TECHNICAL NOTE

LAND AT BURDELL ROAD, YAPTON, WEST SUSSEX RESIDENTIAL DEVELOPMENT

Client: Driftstone Homes Ltd
Reference: 6145

Date: July 2021

Drawing Status	FINAL		
Client	Driftstone Homes		
Project	Burndell Road, Yapton		
Drawing Title	Pedestrian Visibility Splays		
Scale	1:250	Date	July 21
Drawn By	SMO	Checked By	ALB
Drawing No.	2020-6145-005		Rev. C

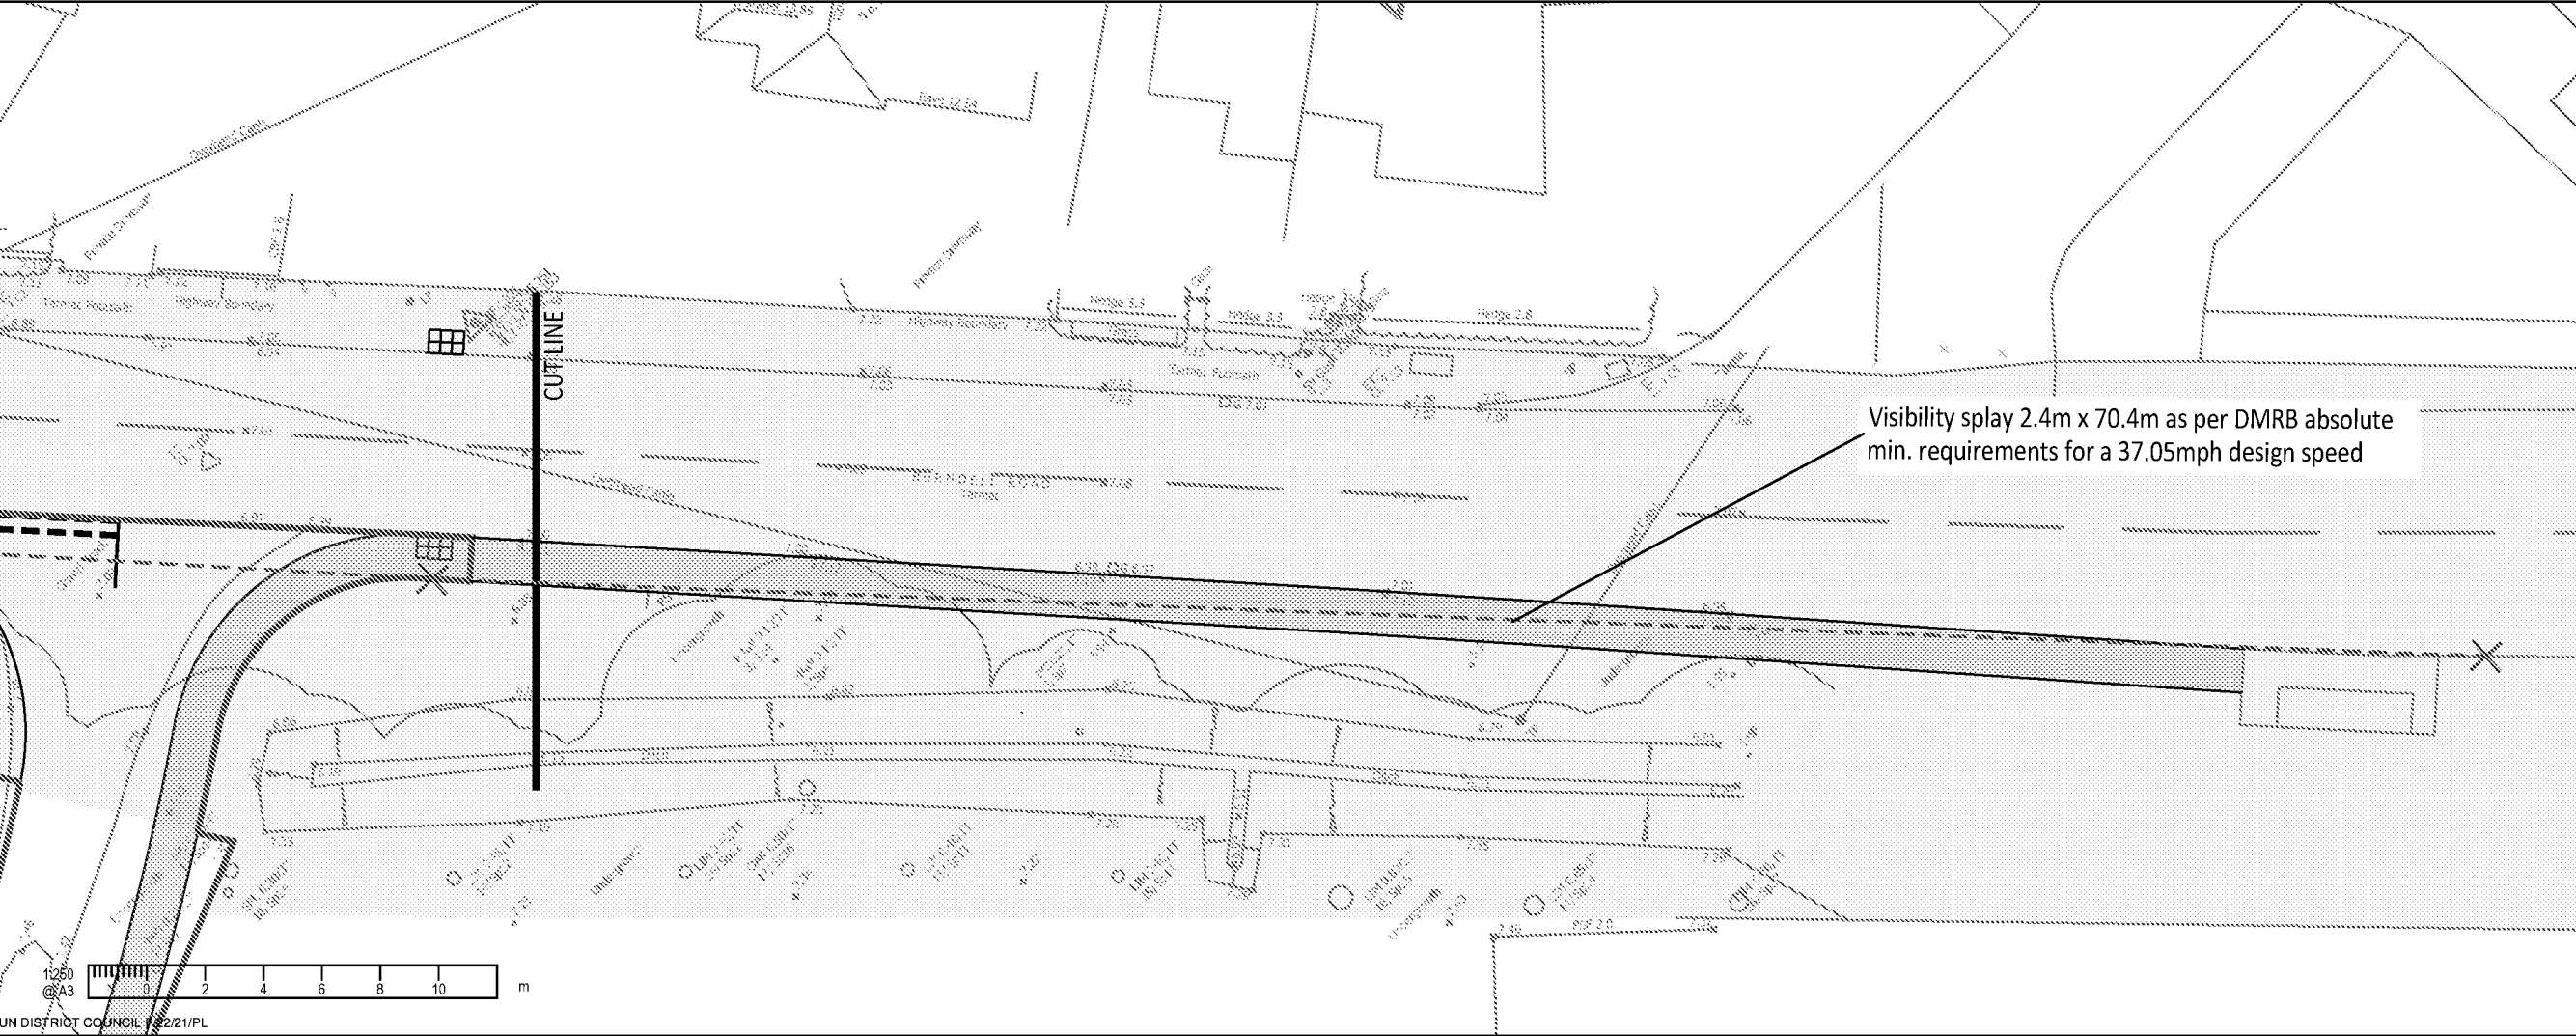
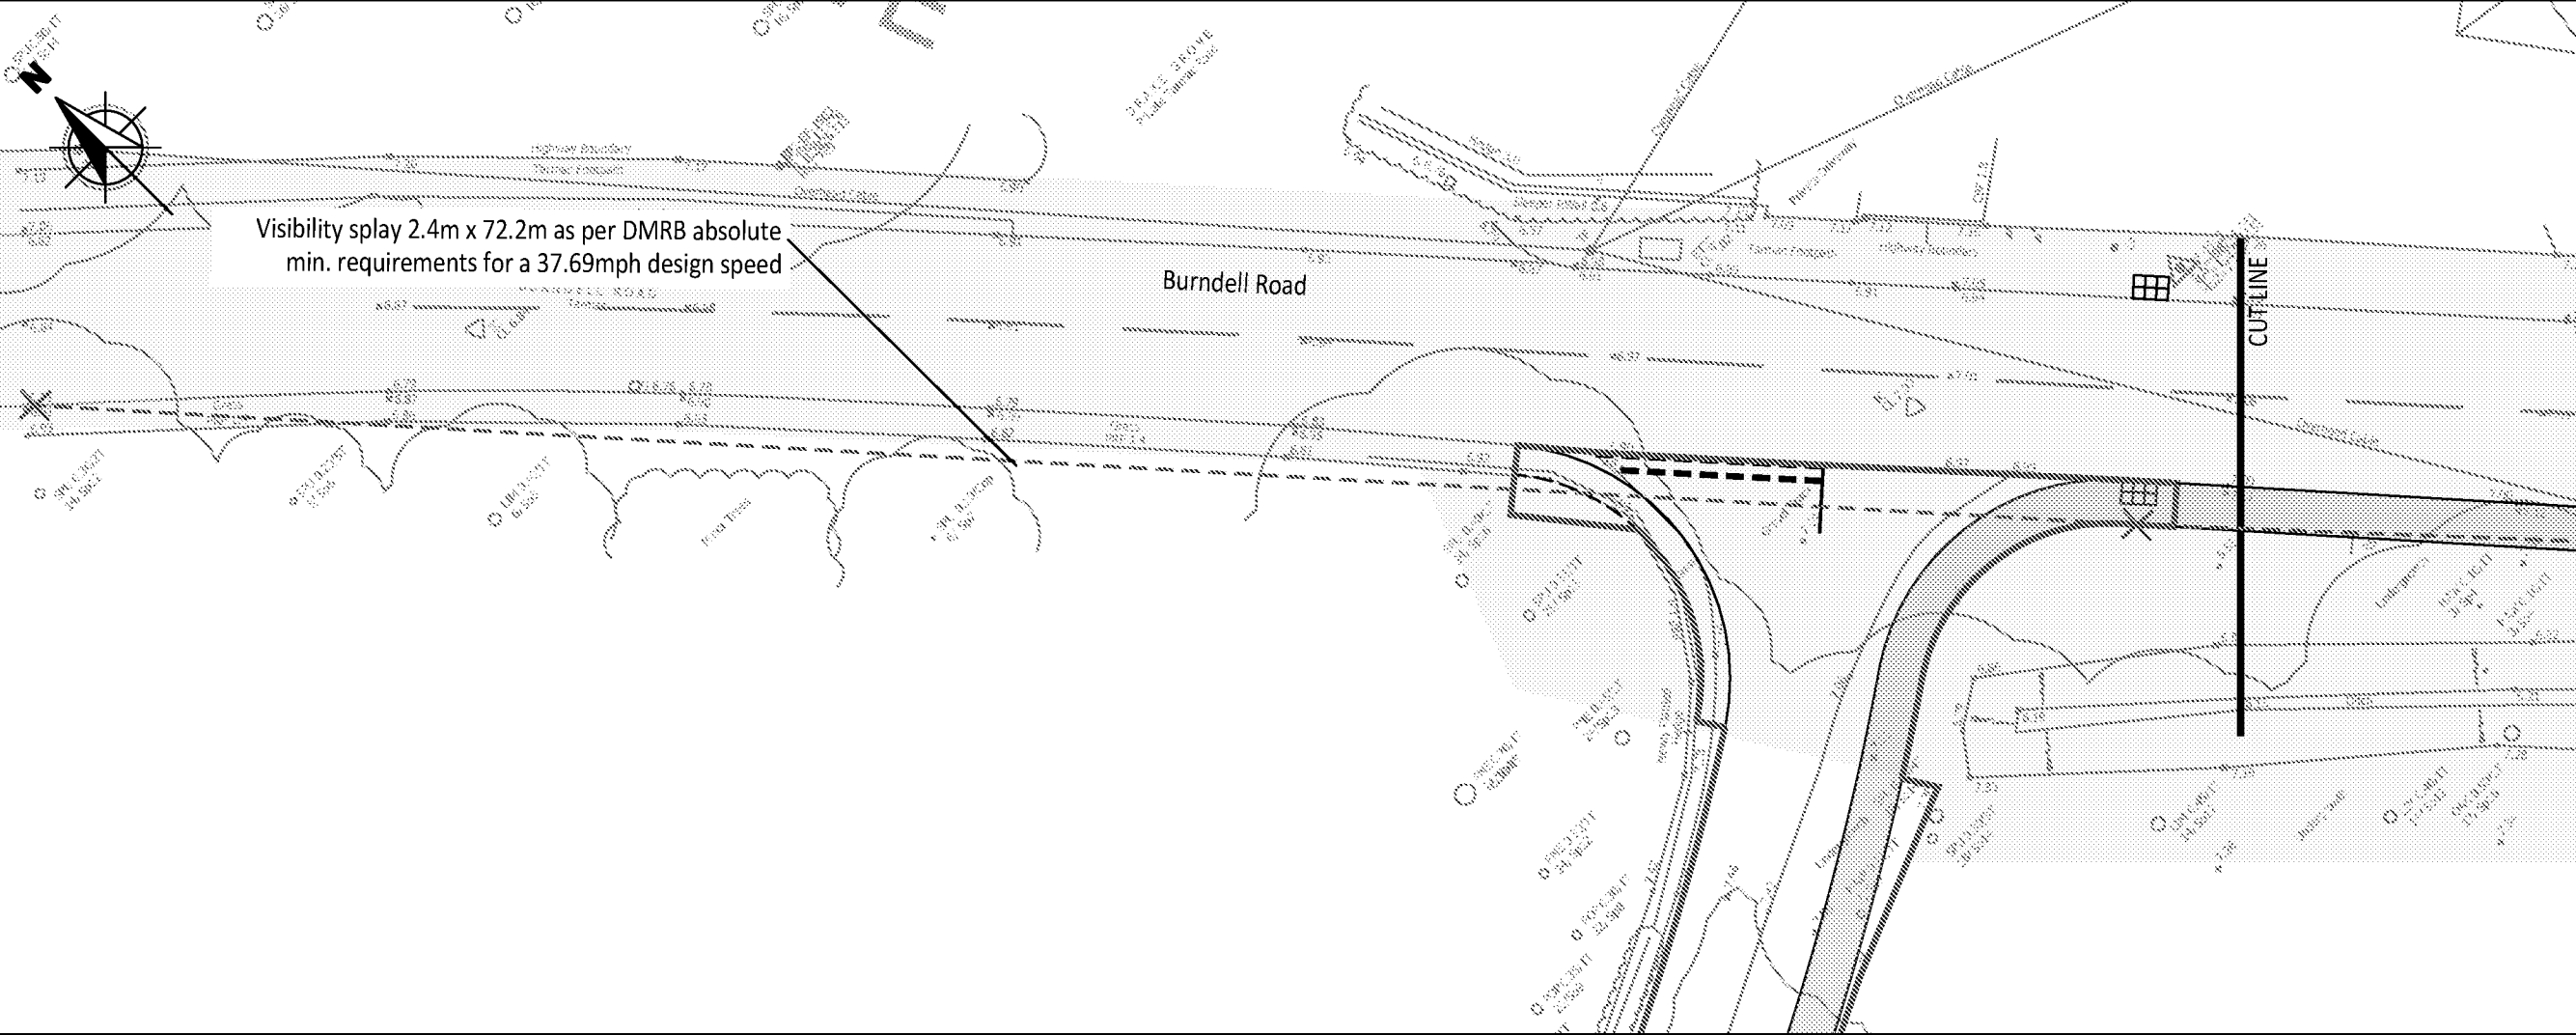
"ATC surveys taken during lockdown periods are acceptable for use in calculating 85th percentile speeds and concurrent visibility splay requirements but should not be used for traffic volume counts. The TS has taken a different approach where splays concurrent to the speed limit of 30mph and to a maximum design speed of 60kph (37.3mph) have been demonstrated. As speeds could be varying and above 37.3mph a 7-day speed survey is required to ascertain the up to date 85th percentile speeds in either direction, in vicinity of the access, along with amended vehicle visibility and pedestrian forward visibility splays in accordance with these recorded speeds."

Location: B – Burndell Road south-east of the access junction (Dwg. 2020-6145-005 Rev. B)

Summary: Risk of pedestrian trips, falls and collisions with passing traffic.

The pedestrian visibility splays drawing shows that, 60m away from the proposed uncontrolled pedestrian crossing point on Burndell Road, there is a bus stop and shelter for north-westbound buses (photo 3).

The footway on the south-east shoulder of the development should be extended 60m to the existing north-westbound bus stop. This will also help safeguard the visibility splay south-eastwards from the development access junction (see problem 2.1 above).

- 2.2.4 Pedestrian visibility from crossings have also been demonstrated in accordance with the recorded 85th percentile design speeds with sight lines calculated using DMRB absolute minimum coefficients in **Drawing 2020-6145-005**.

- 2.3.2 An alternative betterment to the local footway network would however be offered in the form of a new footway to tie in with the 'Rollaston Park' bus stop to the southeast of the site. This additional infrastructure has been provided in accordance with the Stage 1 RSA recommendations.
